CITY OF ALBUQUERQUE

RE: Olague Residence – 9535 Lyndale Ln NW
Grading Plan
Stamp Date: 4/18/17
Hydrology File: C13D032

**Grading & Drainage
Plan**

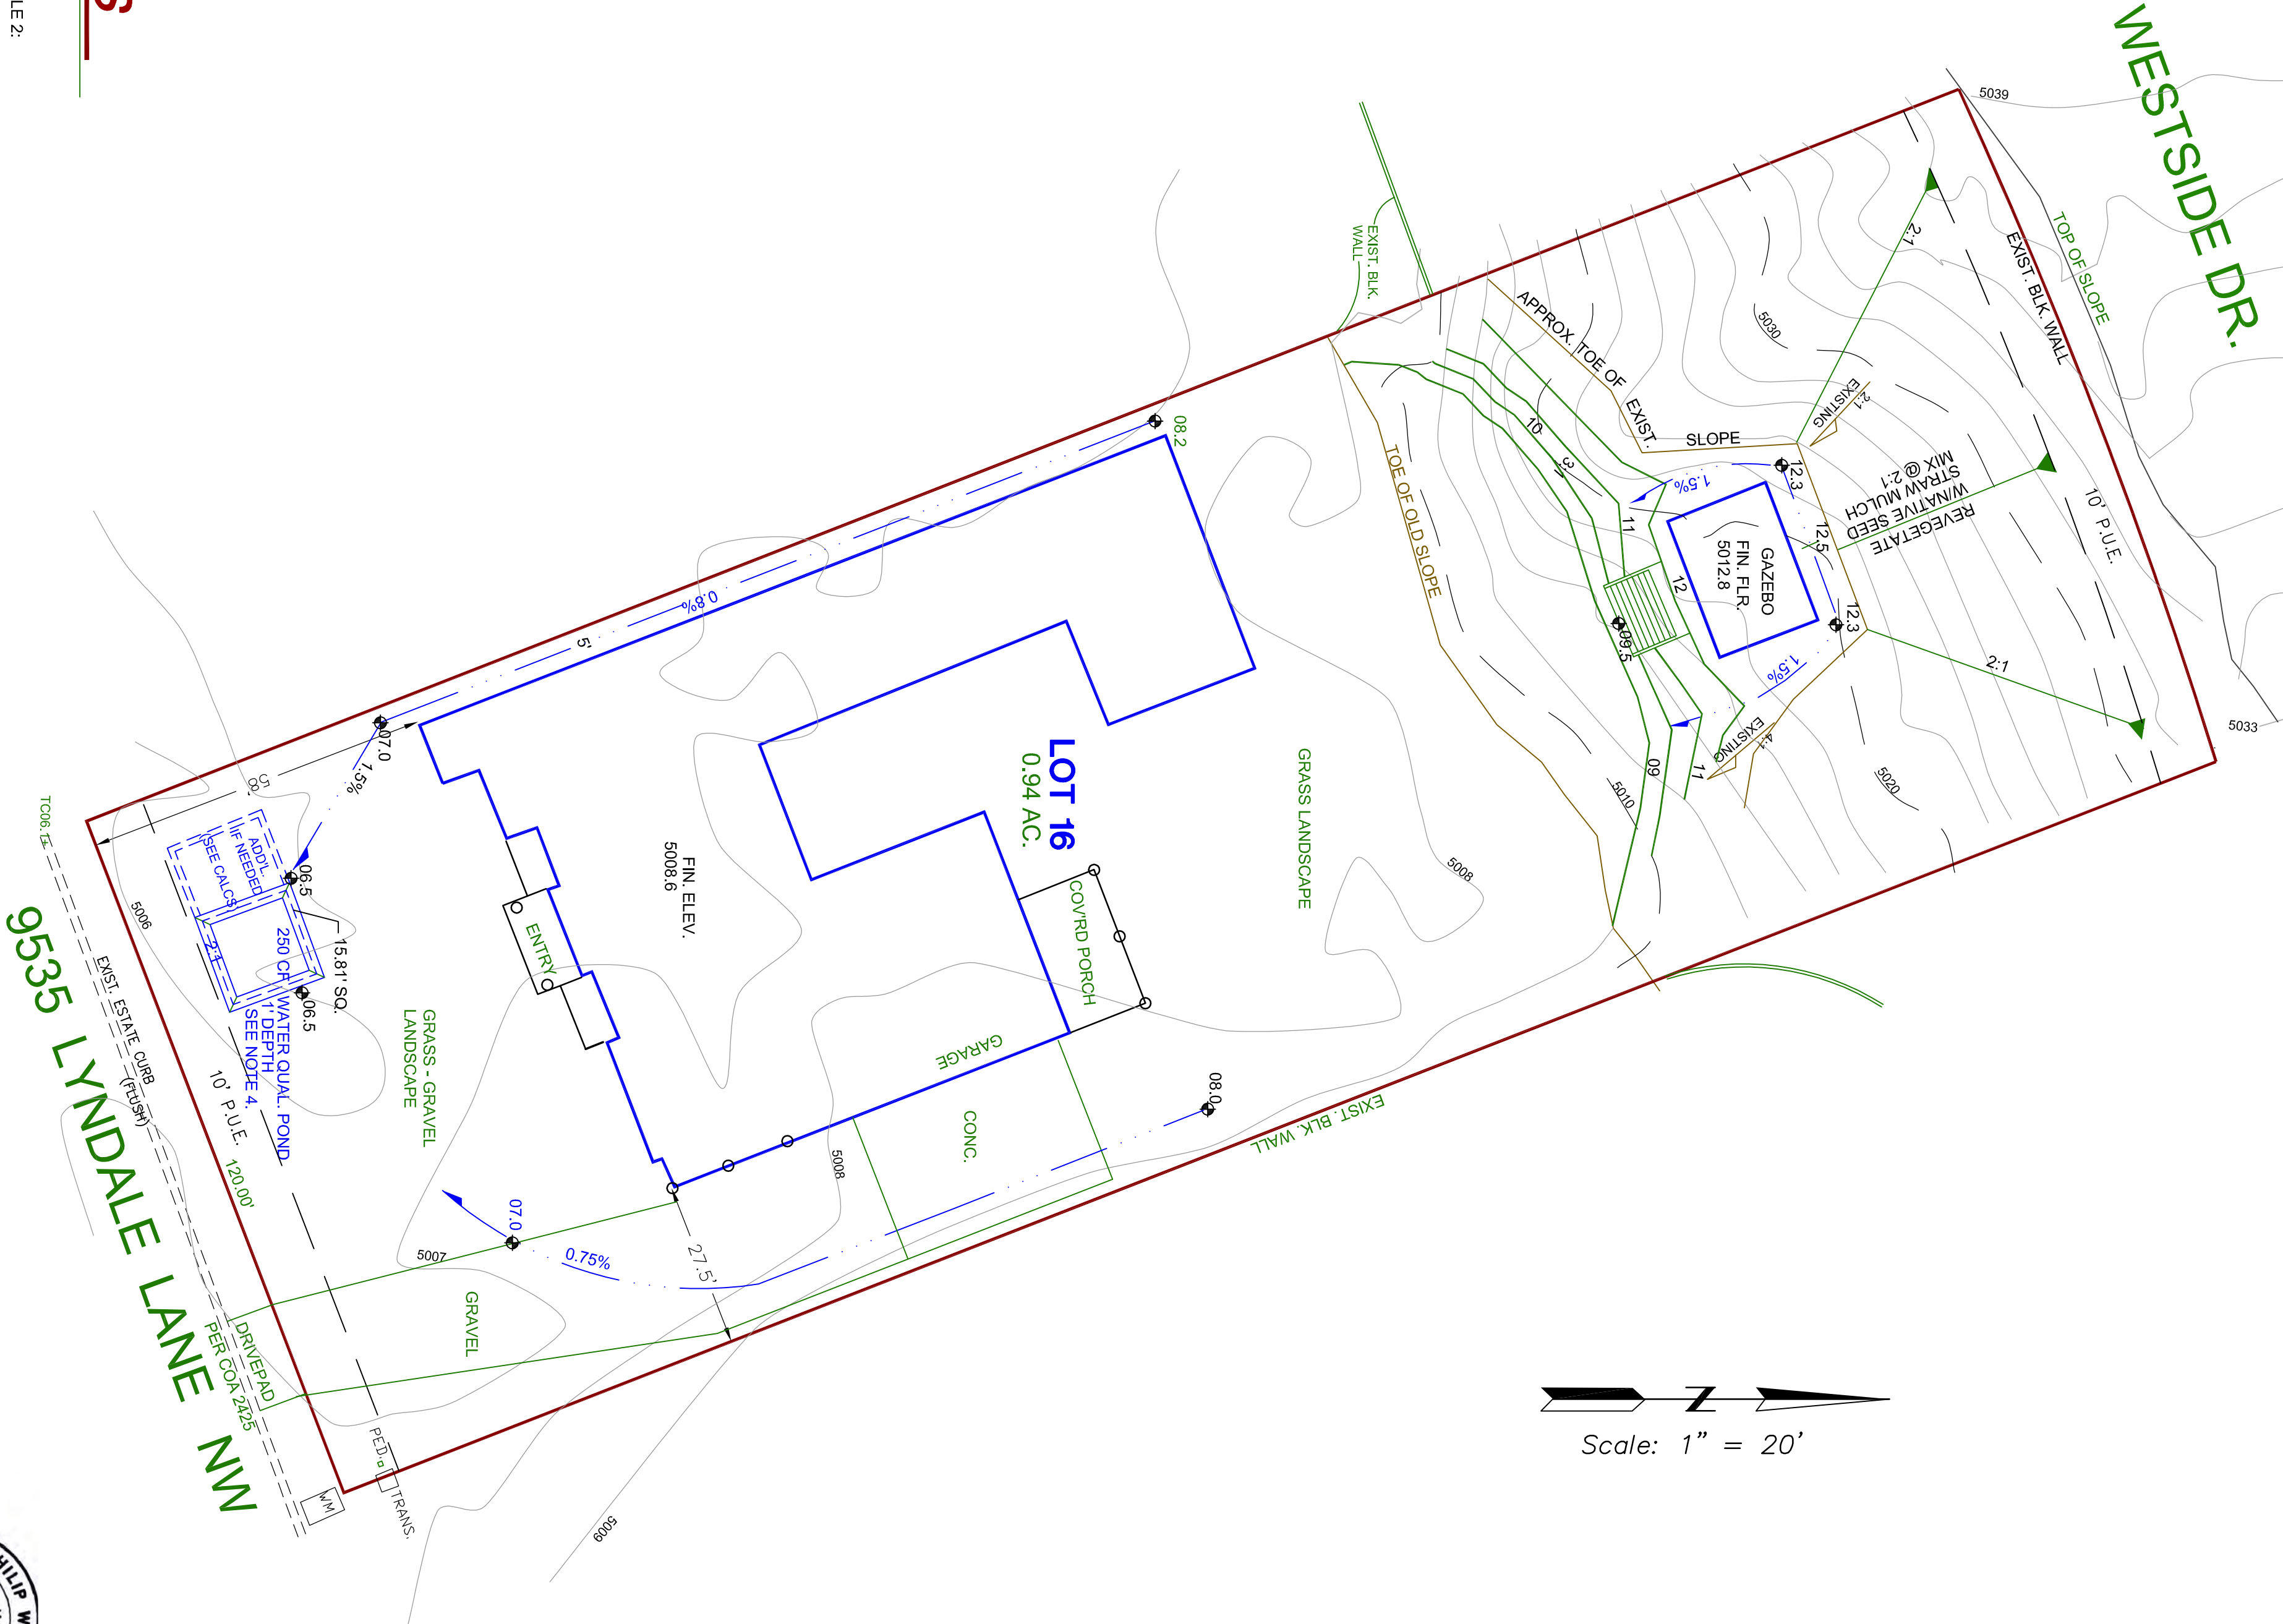
1. Please provide spot elevations at the beginning and bends of all swales. Please also provide the slope of the swales. This was provided for only one of the three swales.
2. In the rear of the lot by the gazebo, proposed contours of 2009 & 2012 are shown. Please also provide proposed contours of the regraded hillside behind the gazebo along with the limit of regrading.
3. Please provide the dimensions of the first flush basin.
4. Please provide a cross section of the first flush basin showing the elevation of the top and height of the pond. Also note a 3" thick layer of cobble or gravel for the pond.
